**Re: State Significant Development Application (SSDA) Assessment –
Submission on Environmental Impact Statement (EIS) * Application Number: SSD-93649710**

Project Name: Lowesdale Pig Breeder Farm

Location: 7550 Riverina Highway, Lowesdale (Lot 125 DP661622)

ONE TREE LANE - CONCEPTUAL PLAN

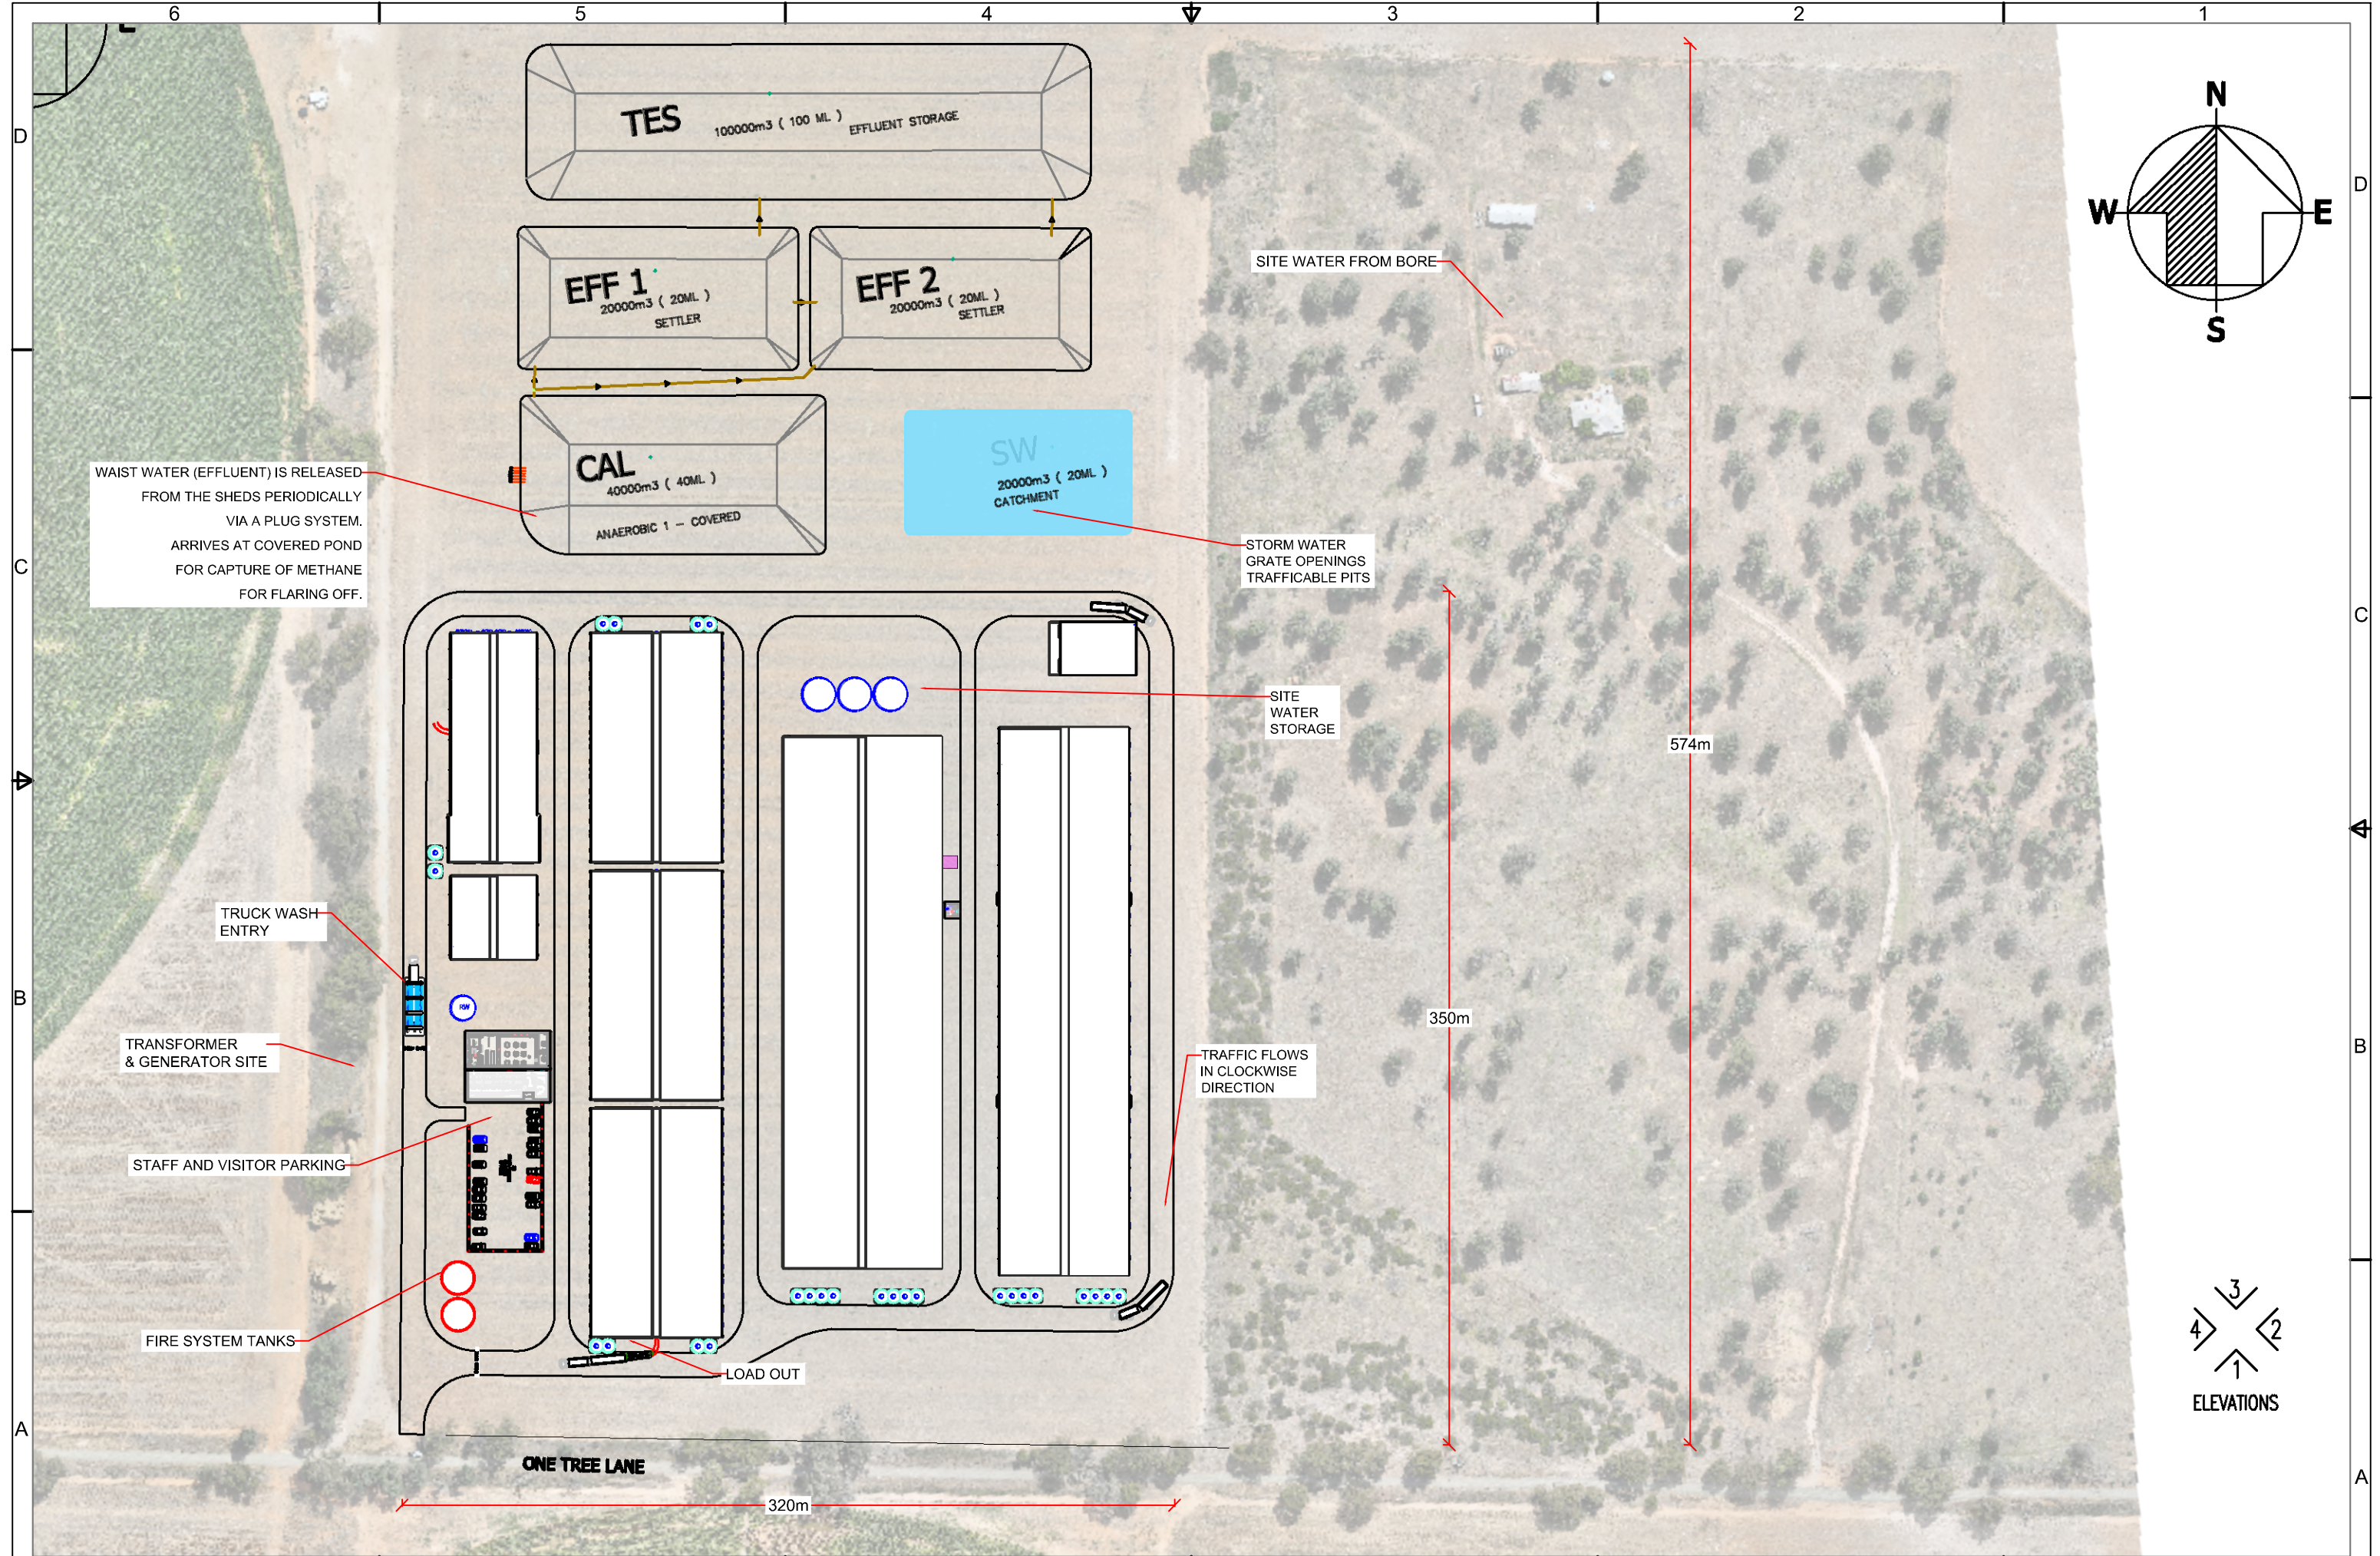
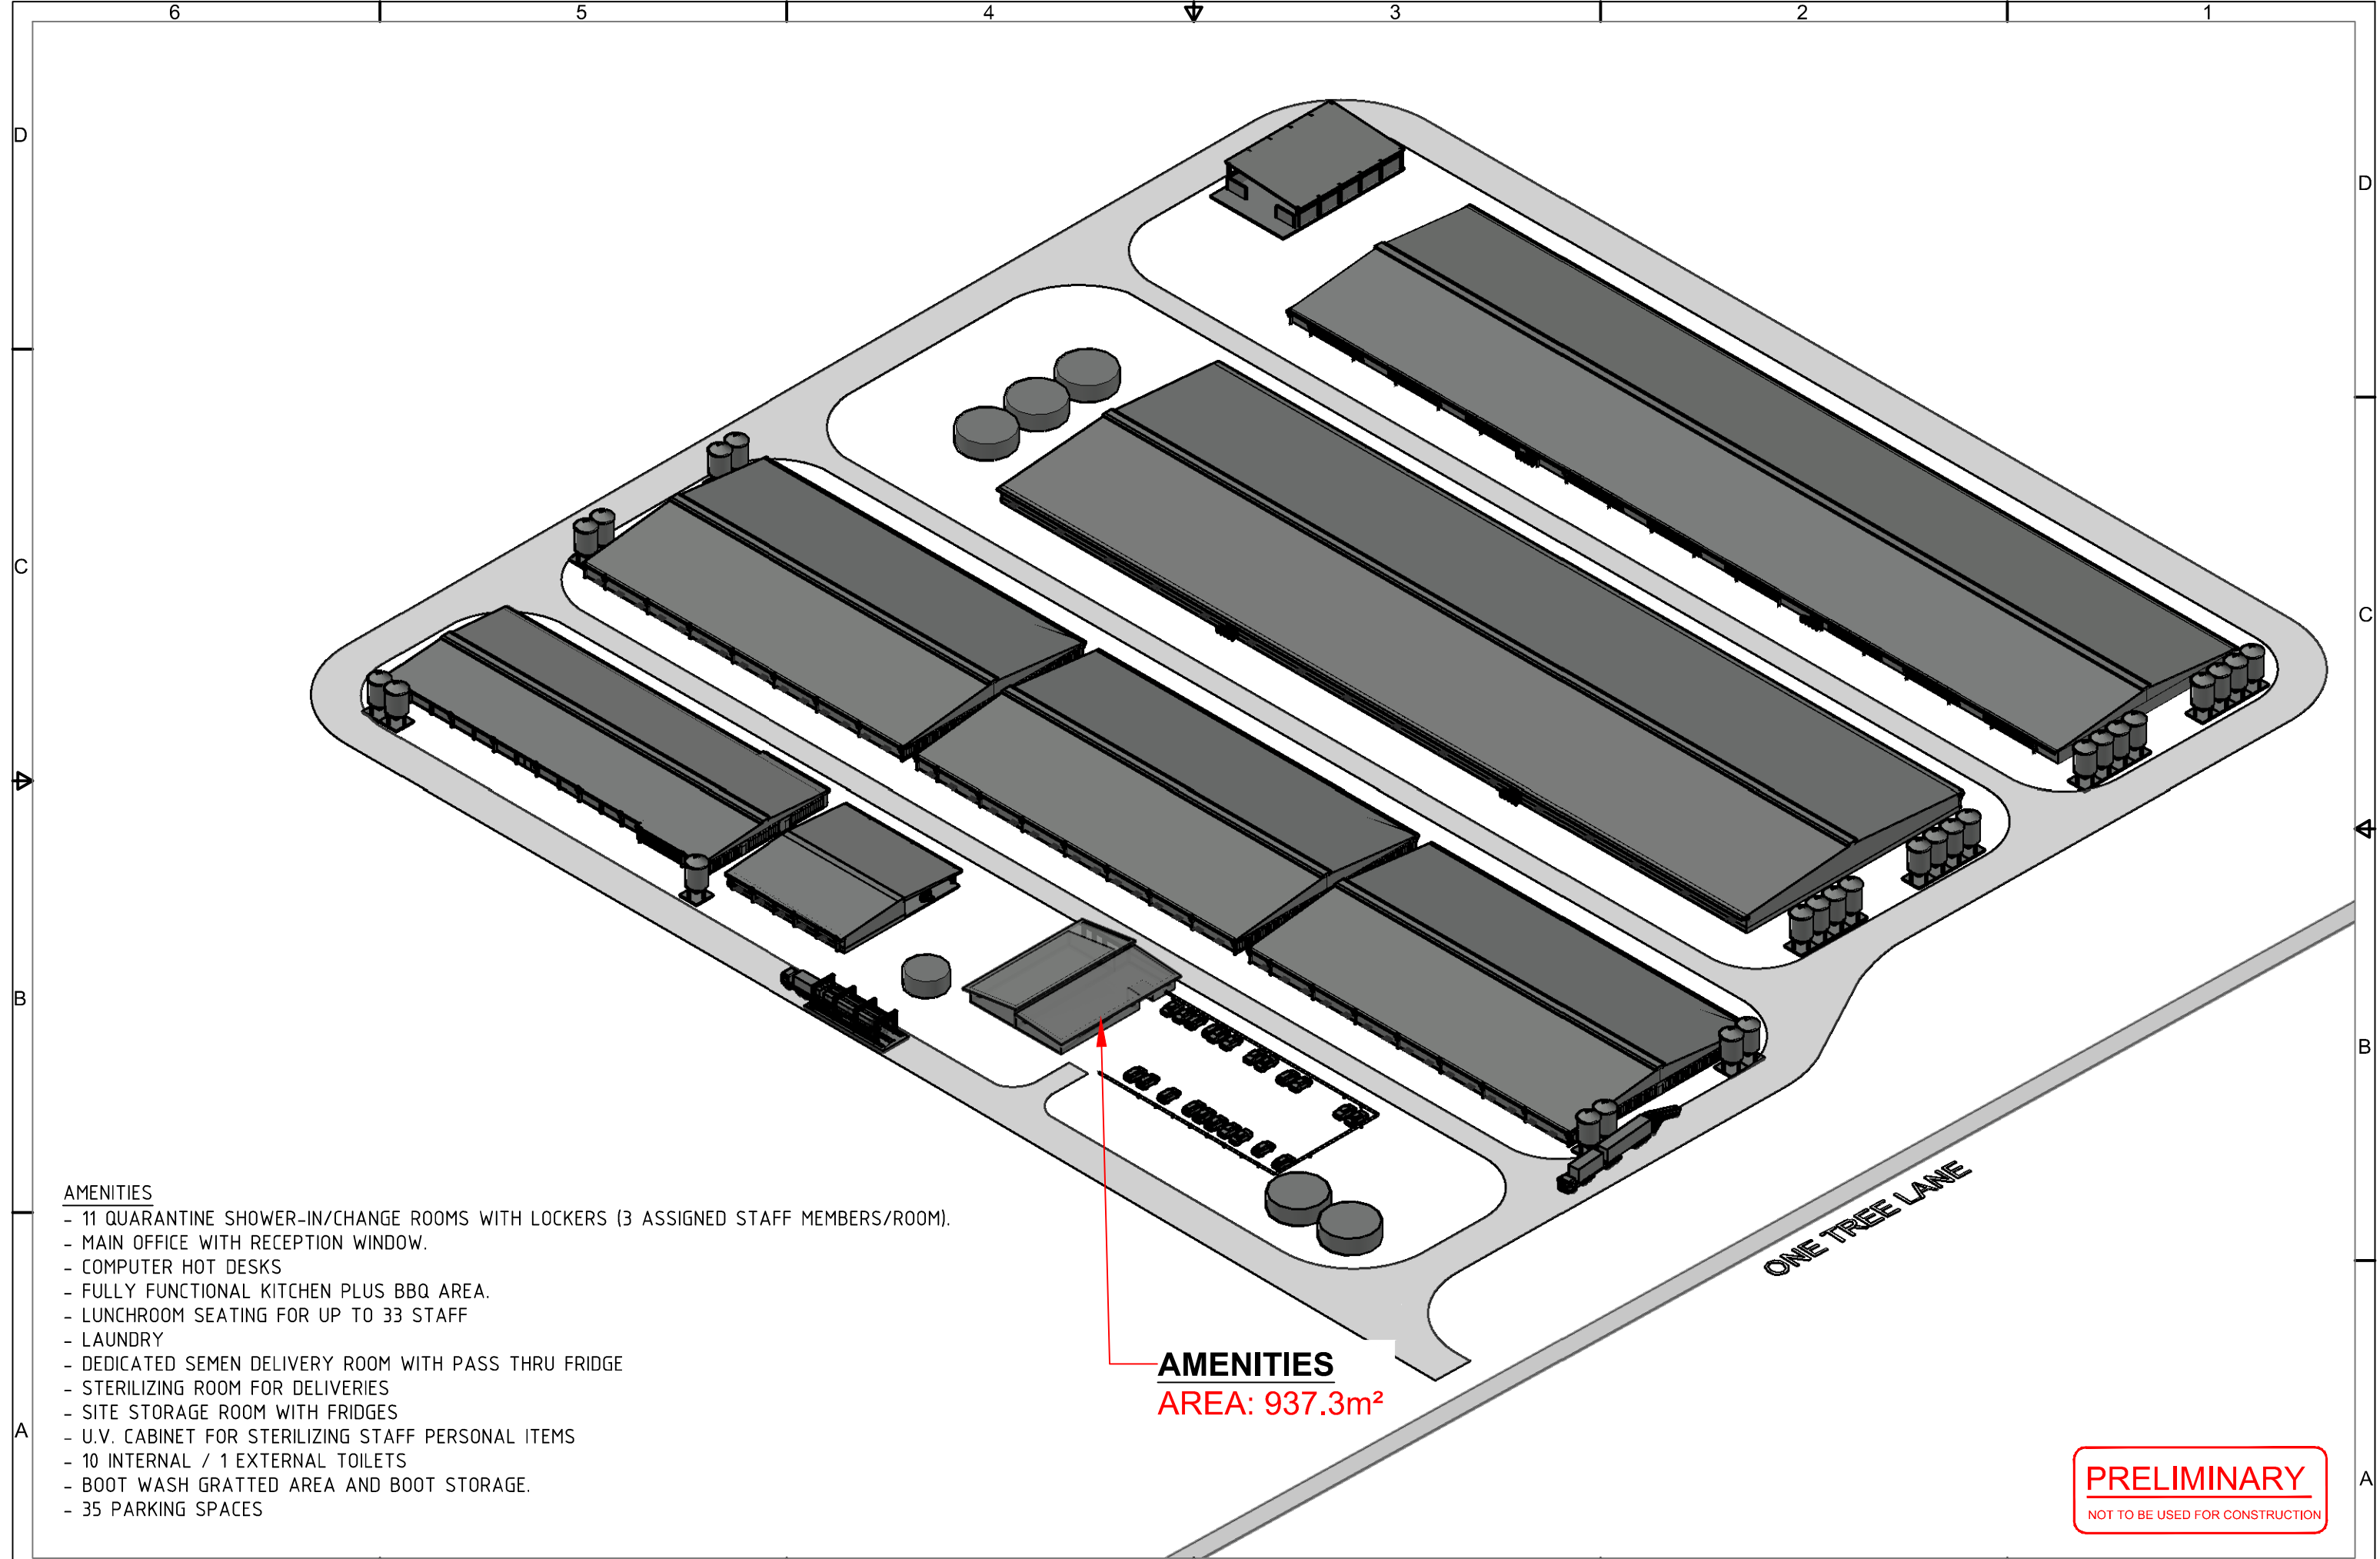
One Tree Lane Road Upgrade: One Tree Lane is currently an unsealed, council-controlled local road. The applicant must be required to fund and execute full gravel-surface road upgrade works to achieve a 6.0-metre carriageway width with 1.0-metre shoulders from the primary development site access directly to the Riverina Highway intersection, completely aligning with Council's Engineering Development Standards.
